Address: 22, Lower Greave Road, Holmfirth, HD9 4DY

Application number: 2025/93257	
What is the application for?:	Variation of conditions 2 (plans and specifications) and 6 (doors, windows and r
Address of the site or building:	Manor Farm, Lower Greave Road, Meltham, Holmfirth, HD9 4DY
Postcode:	HD9 4DY

SOUTH ELEVATION

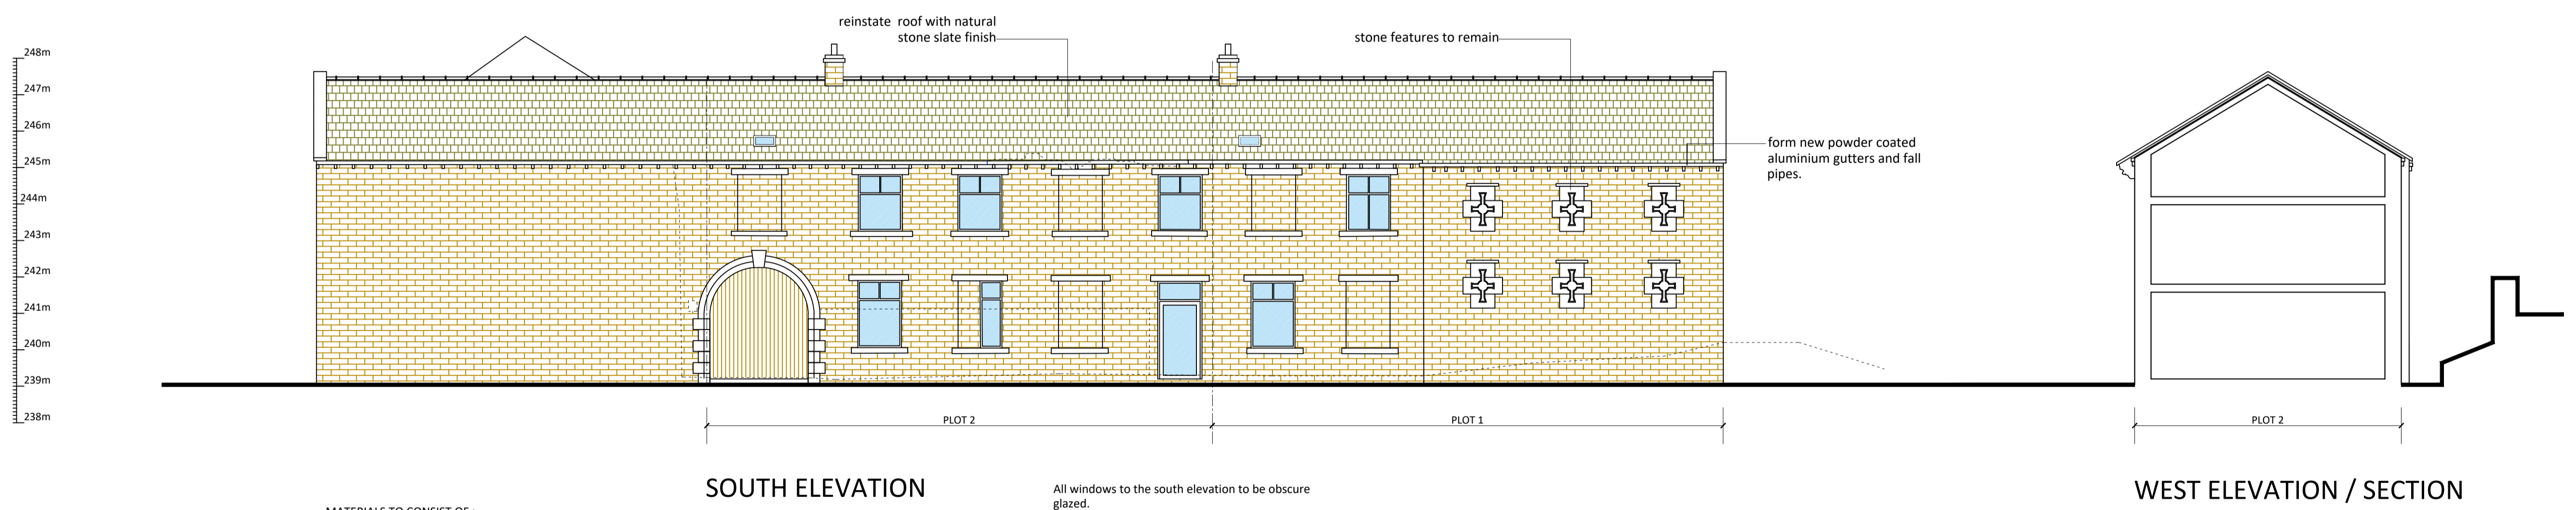
I am the occupier of 22 Lower Greave Road, which is directly in close proximity to the application site. The proposed development includes new windows on the south side lower and upper-floor elevations which would face towards my property and private garden.

The position, height, and orientation of these windows would result in direct overlooking of habitable rooms and private outdoor amenity space at my property. This would lead to an unacceptable loss of privacy for current residents and would materially harm residential amenity.

- * The proposed windows would provide clear views into my living room, garden room and private garden area, resulting in an unacceptable loss of privacy

- * The separation distance between the proposed windows and my property is 2.6m which appears insufficient to prevent overlooking.

The original planning application approval (2021/92596) included measures that would have helped to protect our privacy, such as obscure glazing to any windows overlooking our property and restrictions on window openings. The Developer has blatantly ignored the original planning application approval by changing the style of the windows previously approved.

If permitted, the Council should require obscure glazing on the first-floor side windows and fixed shut openings to protect neighbouring privacy.
